From: Andrea Larson [<mailto:Andrea.Larson@mercergov.org>]
Sent: Monday, September 20, 2021 12:23 PM
To: John Galt
Cc: Bio Park; Eileen Keiffer; Mary Swan; Jeff Thomas; Alison Van Gorp; 'Courtney Kaylor'; 'Rich Hill'; 'Bill Summers'
Subject: CAO15-001/ VAR18-002 - MI Treehouse

On August 7, 2020, you issued Findings of Fact, Conclusions of Law, and Decision, remanding the RUE and Variance for CAO15-001 & VAR18-002, MI Treehouse, for further action by the applicant and review by the City.

SITE PLAN
5637 MERCER WAY
MI TREEHOUSE, LLC
 11030 SE 30TH ST
 BELLEVUE, WA 98004

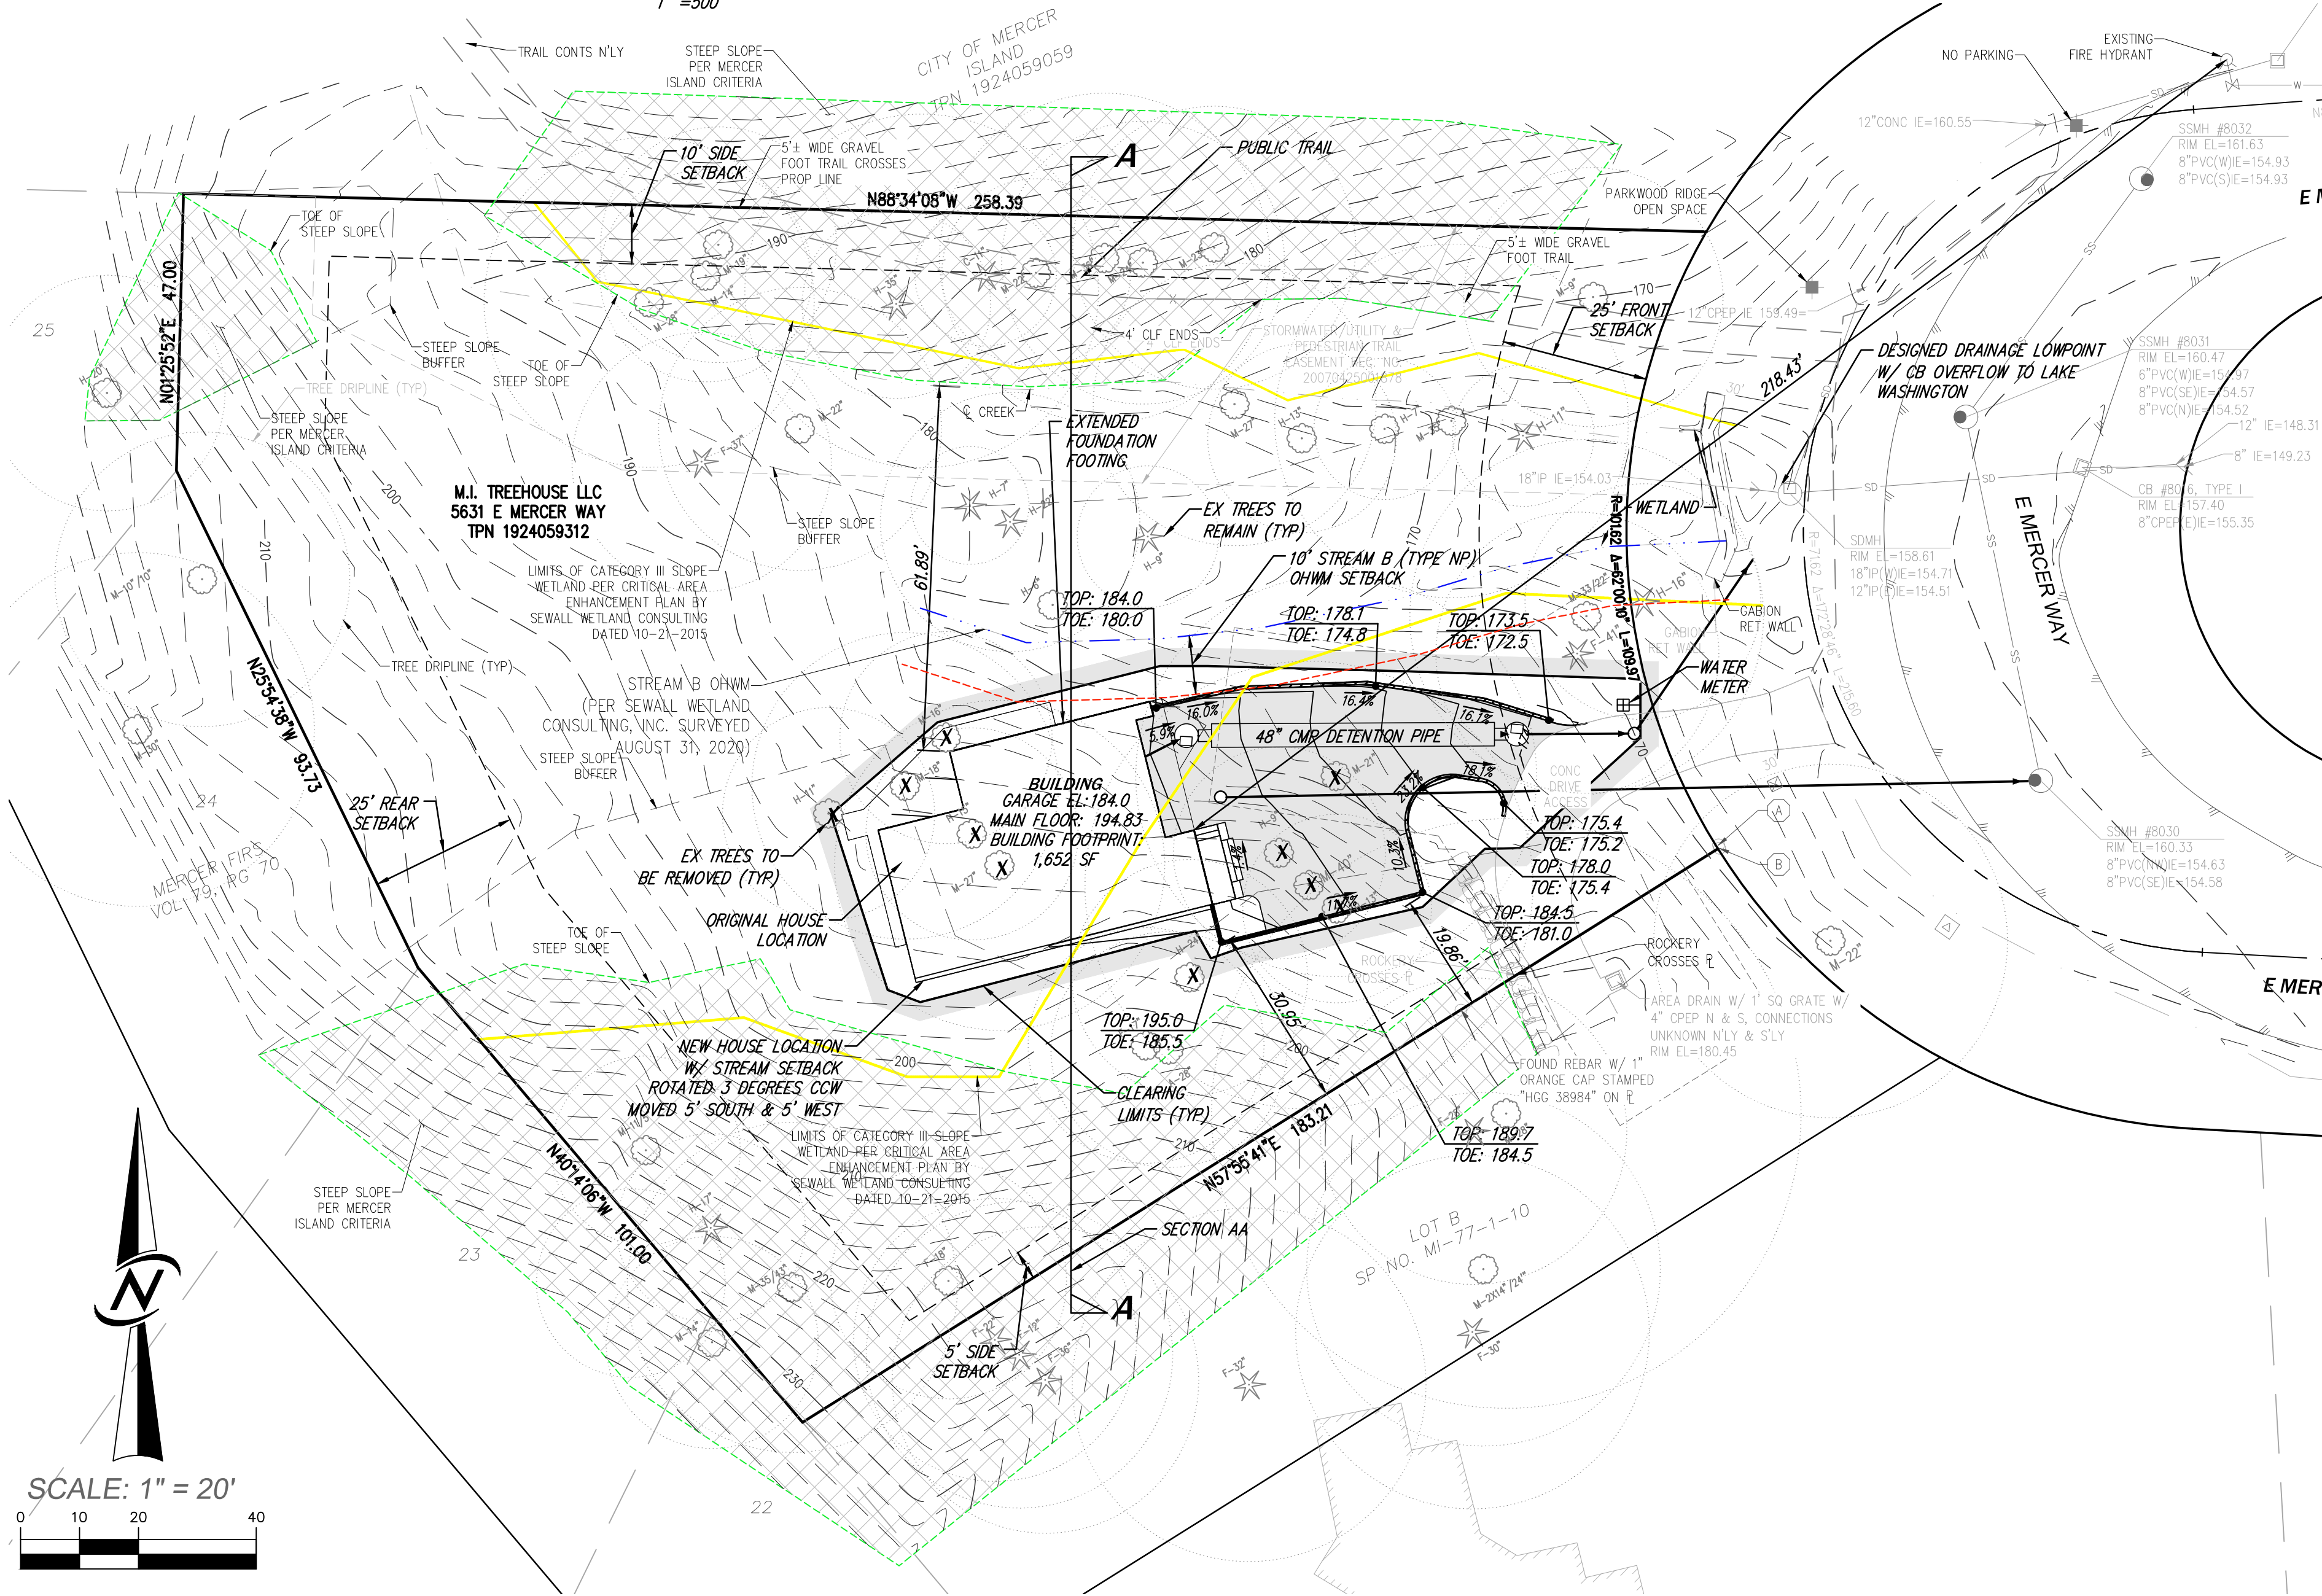
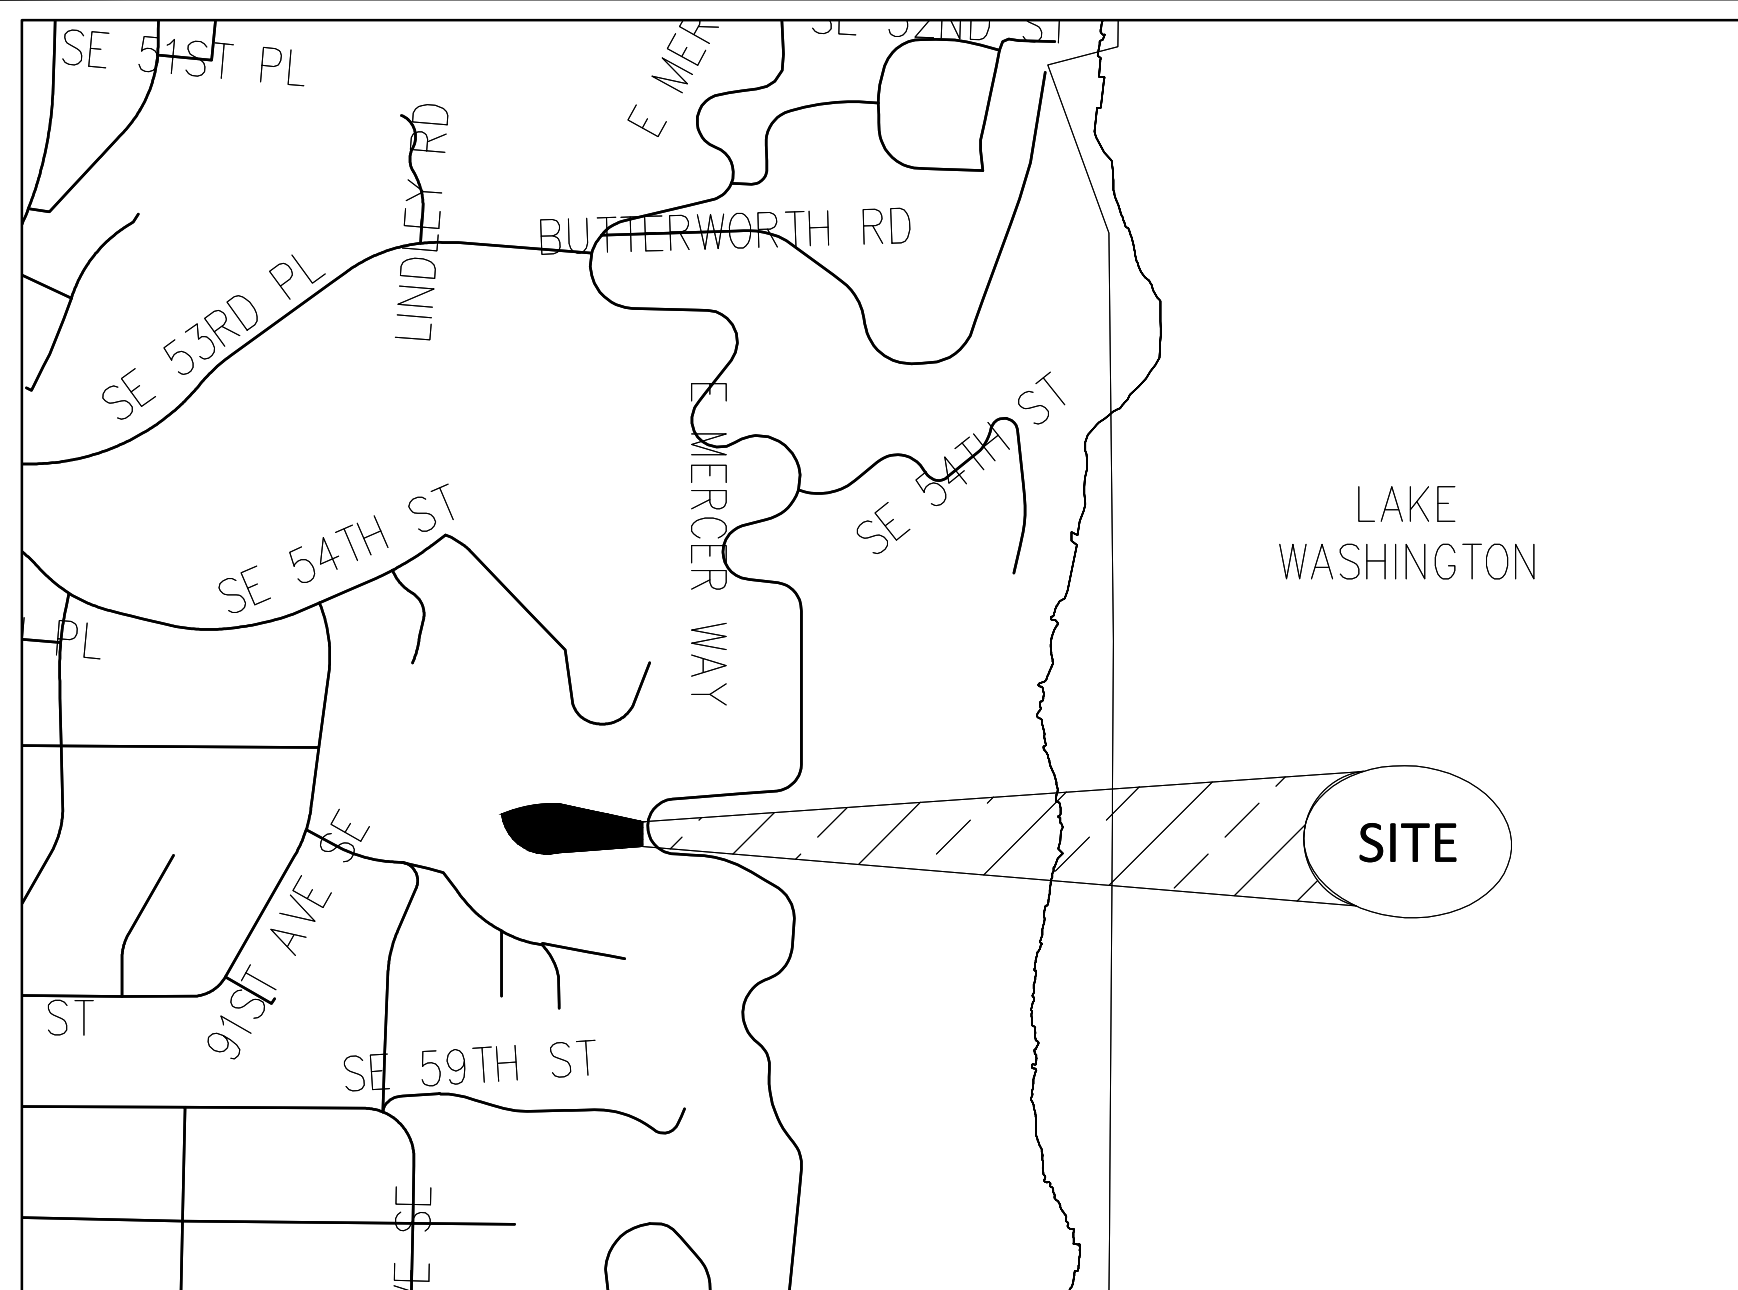
- Stream B: The building should be at least 10 feet back from Stream B and the location of the stream be verified.
- Geotechnical Evaluation: To consider off-site conditions and impacts. To provide information to evaluate potential impacts, including, but not limited to the geologic makeup of the steep slopes and information about off-site conditions.
- Site Plan Errors/Omissions: The Hearing Examiner outlined a number of errors in the plans stating that the Site Plan did not comply with the City's requirements for RUE site plans.
